**Application by Highways England for an Order Granting Development Consent for A38 Derby Junctions Project.**

**Further Submissions by Mr. and Mrs. M. J. Beavis (The Beavis Family). references:- A38DJ-AFP070/1 - Further Ref:- 20022809.**

**The basis for our Representation – re:- closure/diversion of the Footpath at the newly proposed Little Eaton A38 Flyover**

Drawing Title  
FIGURE 2.7  
LITTLE EATON JUNCTION  
GENERAL ARRANGEMENT

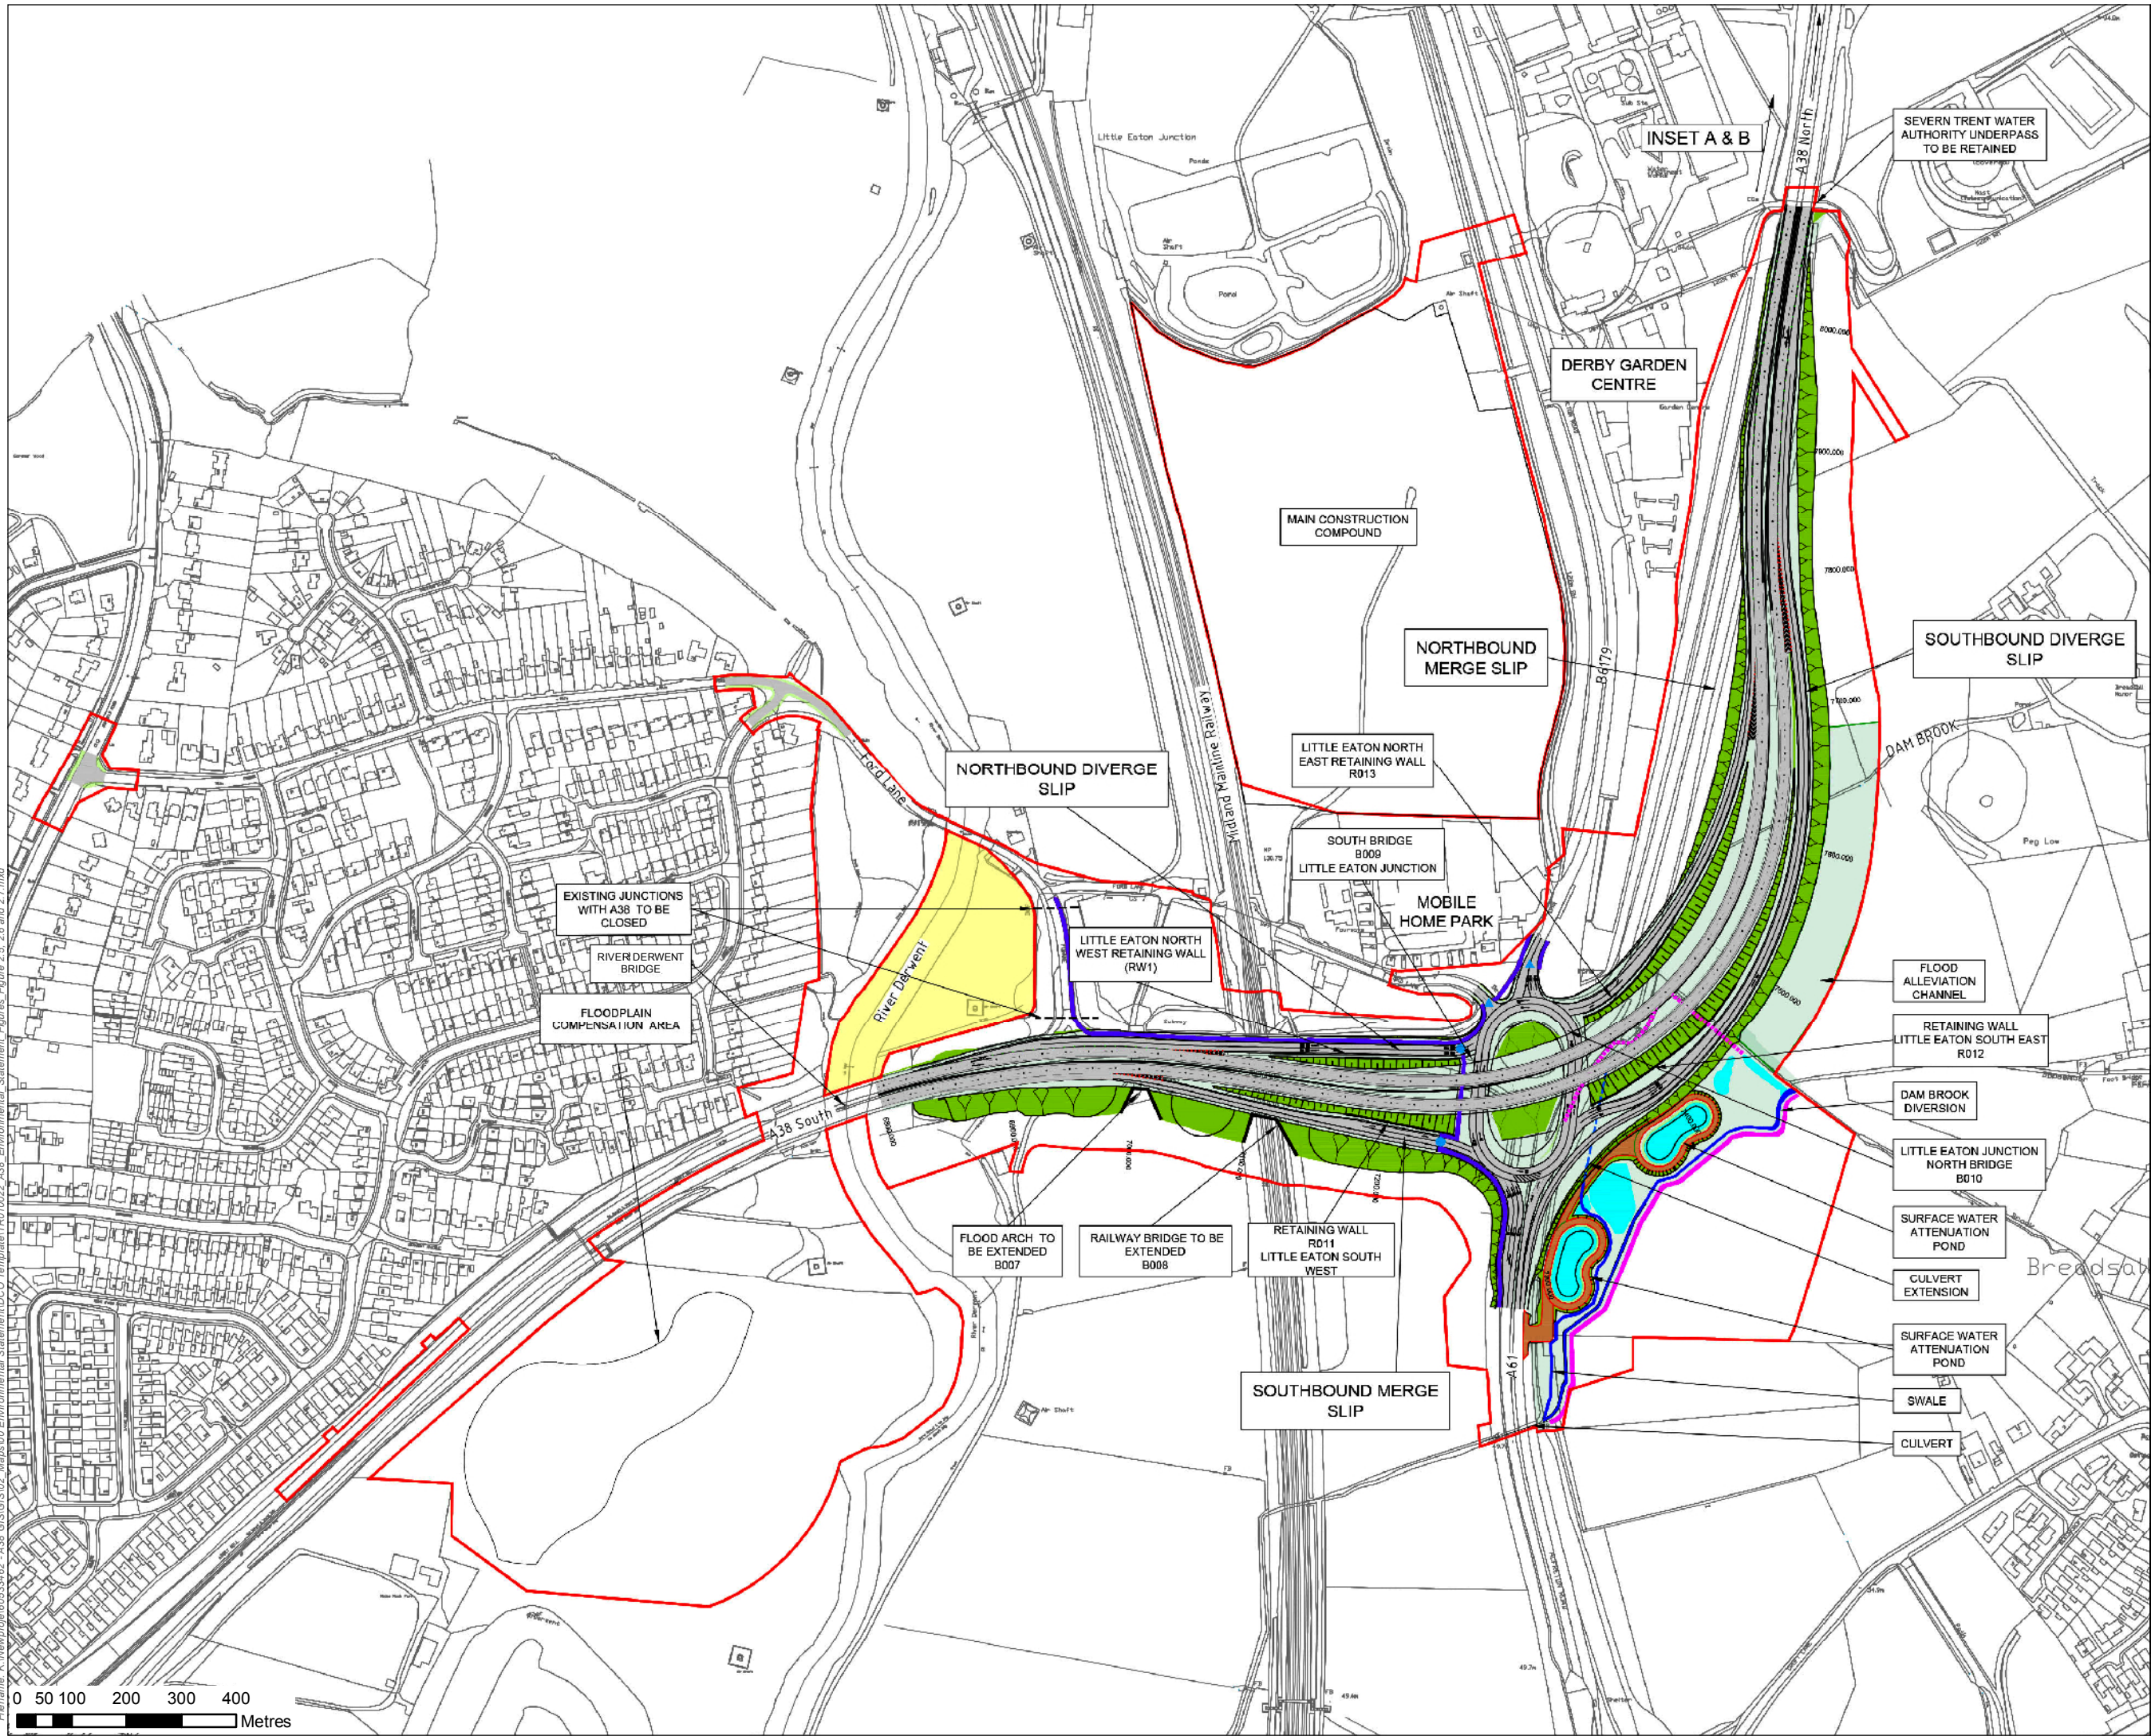
The proposal by Highways England (H.E.) to close and divert Footpath No. 3 from Rectory Lane and Croft Lane to the Little Eaton A38/A61 Island flyover and onto Little Eaton fails to retain this long established route. This is specifically signed on Croft Lane. Furthermore, the proposed diversion returns the pedestrian south (in the wrong and opposite direction), adjacent to A61, to join F.P. No. 1 on its route to Darley Abbey. Such a route would mean it necessary to cross the dual carriageway of the A61 at some point, which is fast moving, with no provision for the pedestrian to cross and then return some distance north, to encounter the complex new fly-over and road pattern at the Little Eaton A38 flyover, on their route to Little Eaton. A footpath should provide a direct route between two places.

It seems illogical to expect walkers to travel south for about a quarter of a mile, along the proposed new route, adjacent to the A61, to then have to return a similar distance north. Obviously the footpath, currently at the A38 Island, should be routed north (on the Breadsall side), alongside the eastern side of the newly positioned A38, to meet up with Bridle Path No.18, adjacent to the Severn Trent Water Works, using the existing underpass, to safely arrive in Little Eaton. No major road would have to be crossed and the original purpose of the F.P. achieved.
